CITY OF ALBUQUERQUE

December 2, 2014

**Re: I40 South and Unser Mini DMP
Engineer's Stamp Date 11-5-14 (K09D026)**

Reservoir "POND 6" Results for Run "DEVEX_1"

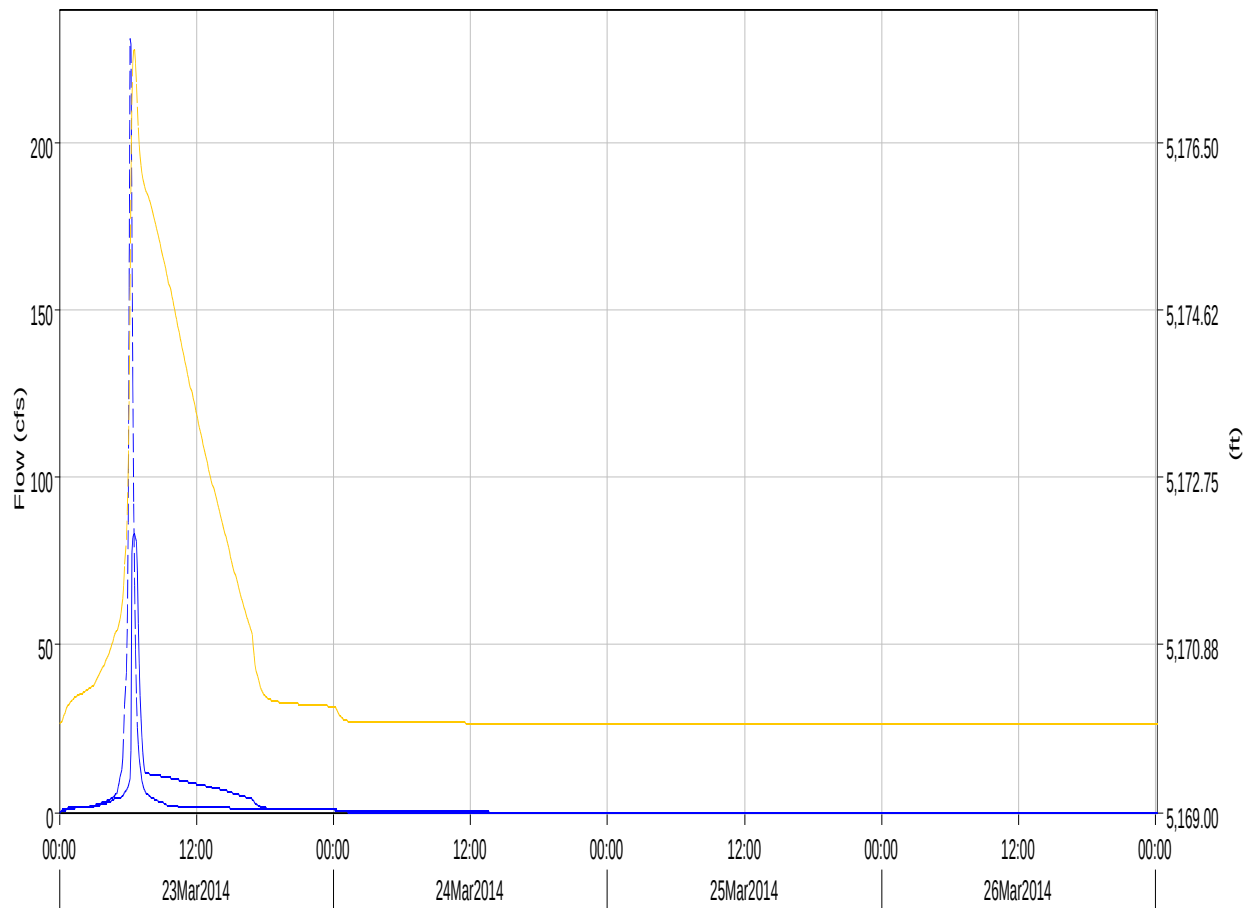
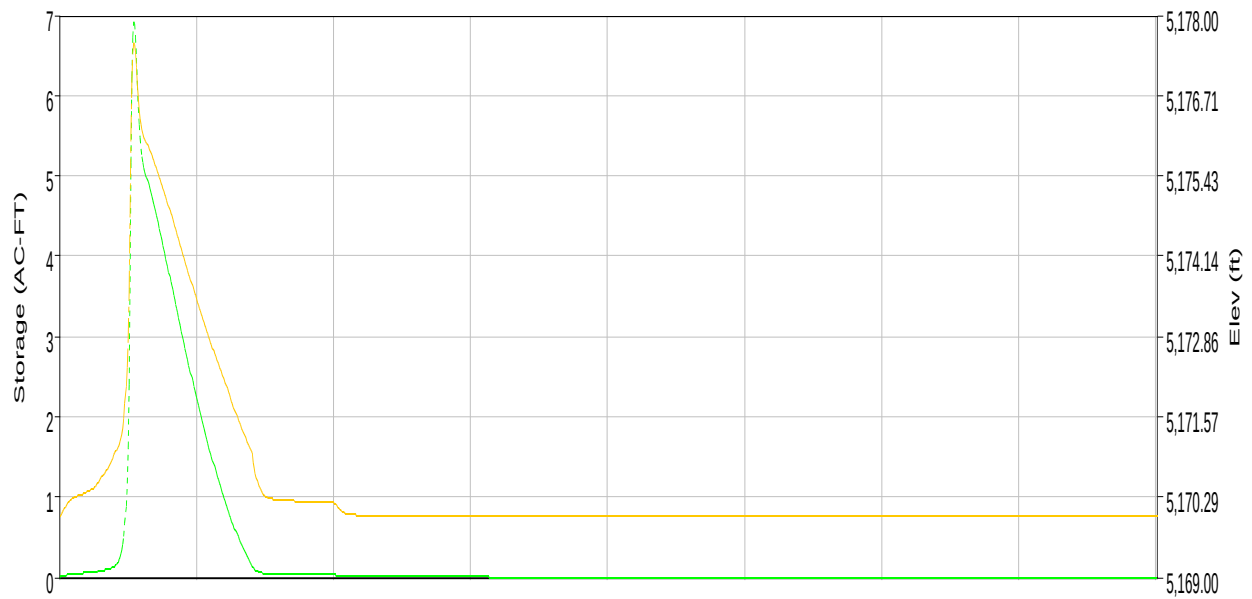
Hydrology's comment that the freeboard for Pond 6 is insufficient at 0.4 feet is still valid. Future drainage reports for basins that drain to Pond 6 will have to address this comment. Most likely it will not be an issue as development will most likely occur at a lower impervious percentage than used in the report and this report was submitted prior to the City's first flush requirement of retaining the runoff from 0.44" storm events.
